**RHS SUBMISSIONS ON
THE DCO SCHEME
IN RELATION TO
REGULATIONS 63, 64 AND 68
OF THE
CONSERVATION OF HABITATS AND SPECIES REGULATIONS 2017**

1. The Government-owned Strategic Highways Company (formerly Highways England) (“**HE**”) has made an application for a Development Consent Order under s37 of the Planning Act 2008 in relation to the M25 junction 10/A3 Wisley interchange improvement scheme (the “**DCO Scheme**”).

Figure 1: Wisley & Ockham Commons Management Plan 2010 – 2020 management prescriptions for woodland clearing / felling shown with the 150m buffer zone from the roads

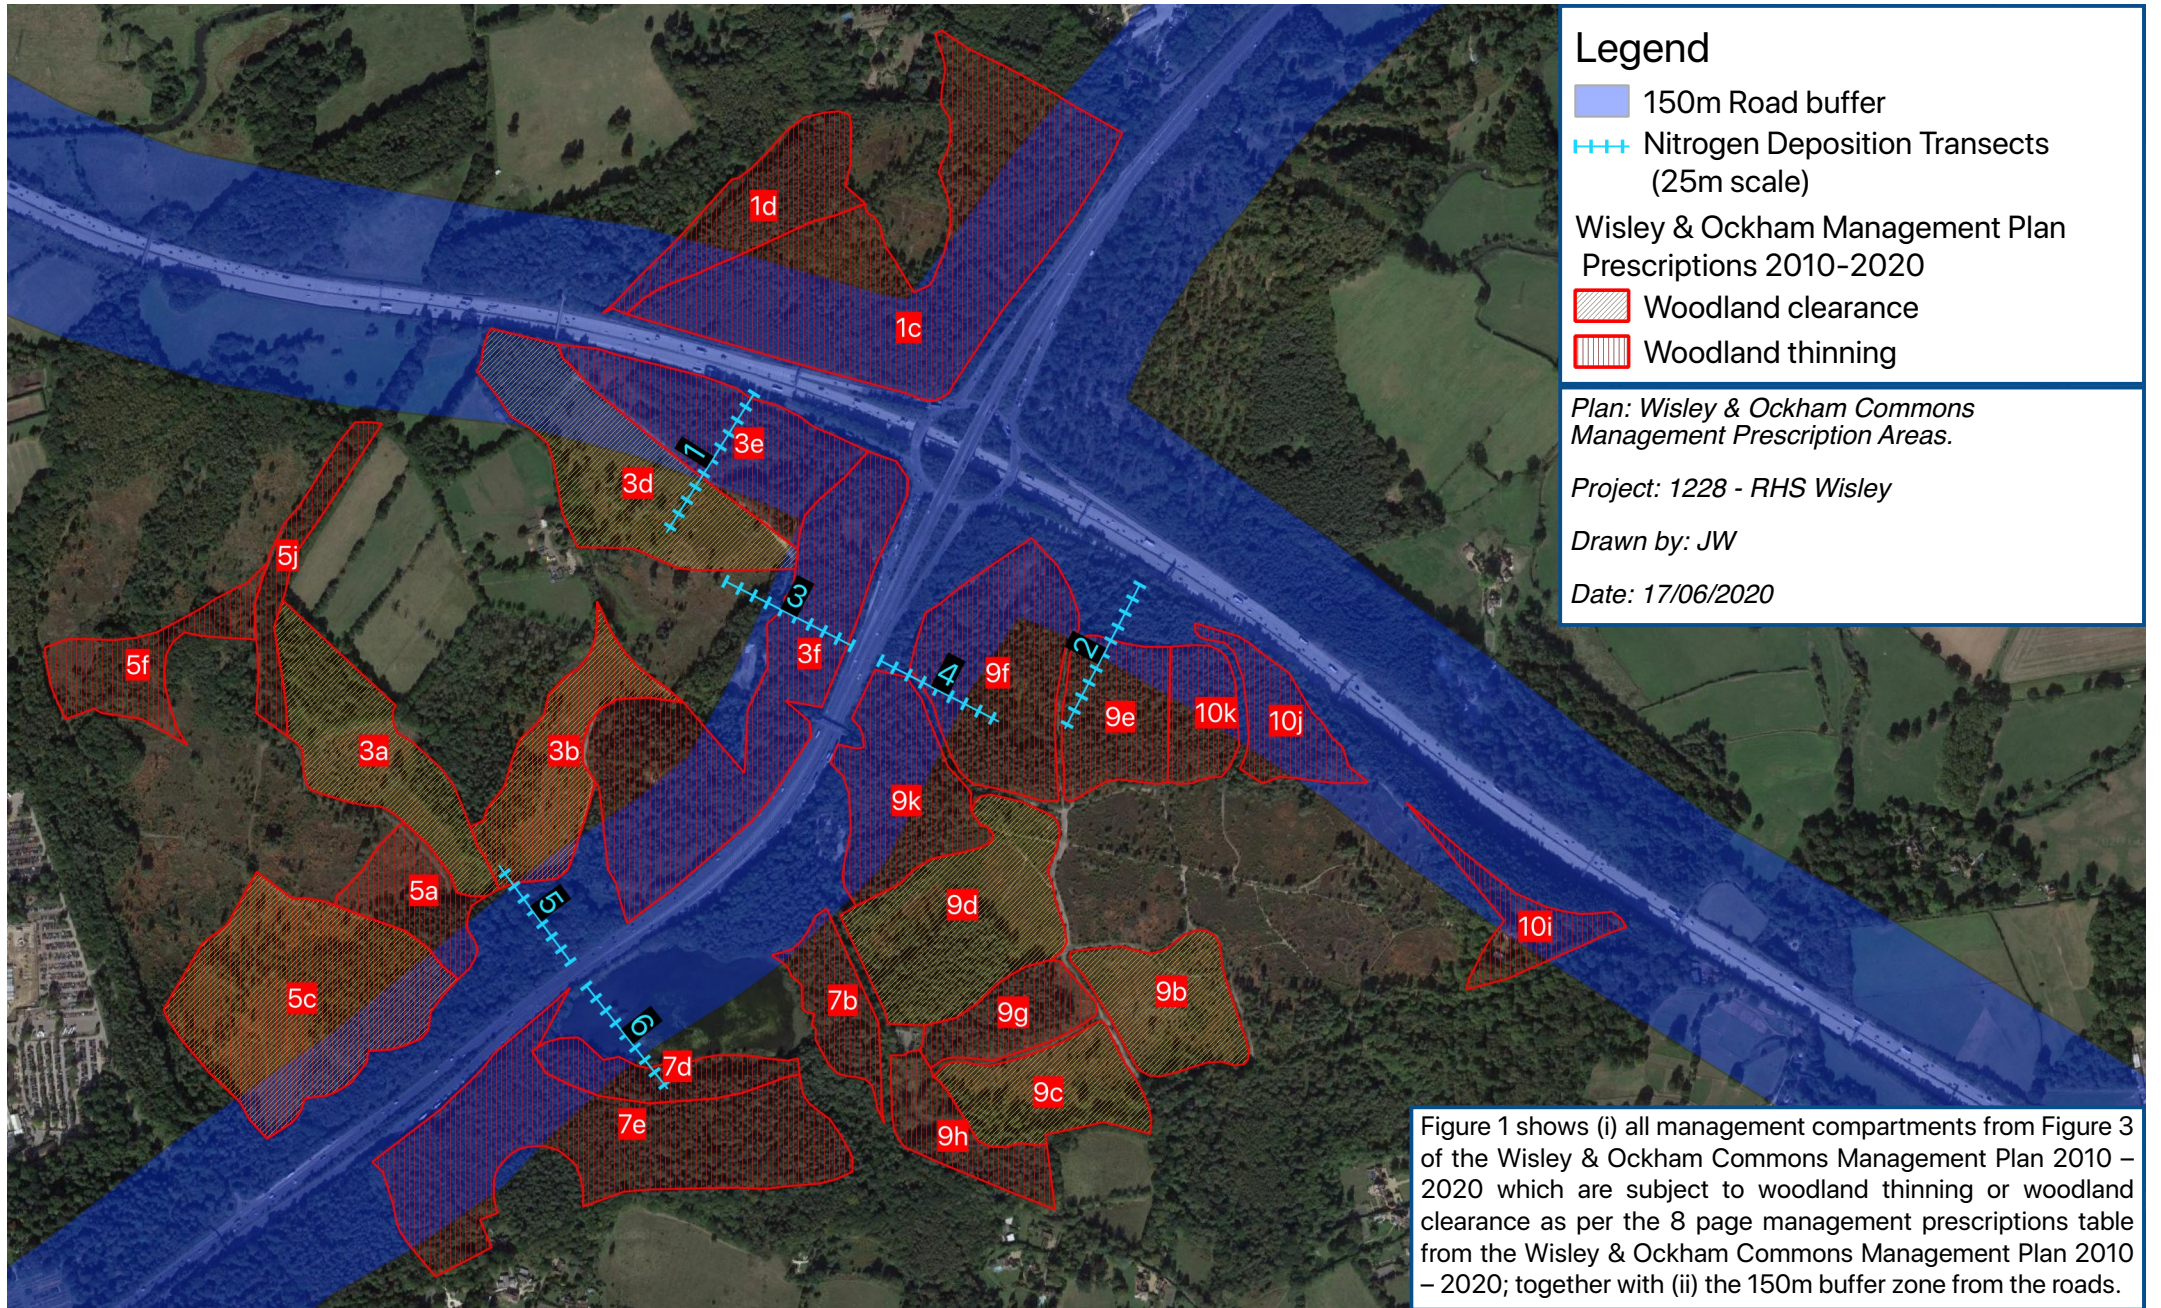
43. Baker Consultant Ltd’s Figure 1 (REP11-042) shows in particular the Wisley & Ockham Commons Management plan prescriptions for woodland clearing and thinning *within the 0m-150m woodland zone*.
44. Of the compartments prescribed for woodland *clearing* under the Management Plan, compartments 5c, 3b and 3d partly fall within the 0m-150m zone.
45. For the management compartments prescribed for woodland *thinning* under the Management Plan, compartments 5c, 5a, 3f, 3e, 1c, 1d, 7e, 7d, 7b, 9k, 9f, 9e, 10k, 10j and 10i all partially fall within the 0m-150m zone.
46. HE (in the NE / HE SoCG REP8-022 (3.2.8)) states:

47. It seems, unfortunately, that both HE and NE have failed to read the Management Plan correctly or in any detail. This is because, when the above statement is compared with Baker Consultants Ltd’s Figure 1, taken from the Management Plan, one sees instantly that:
 - 47.1. Areas of “woodland clearance for heathland restoration” (MH31 02 in the Work Programme table) are to be undertaken in areas within 150m from the roads, see management compartments 5c, 3b and 3d; and
 - 47.2. The above statement has completely failed to mention the large areas of woodland to be thinned in areas within 150m from the roads.
48. The contents of the Management Plan are also not consistent with HE’s ExQ3 answer 3.8.2 (REP7-004):
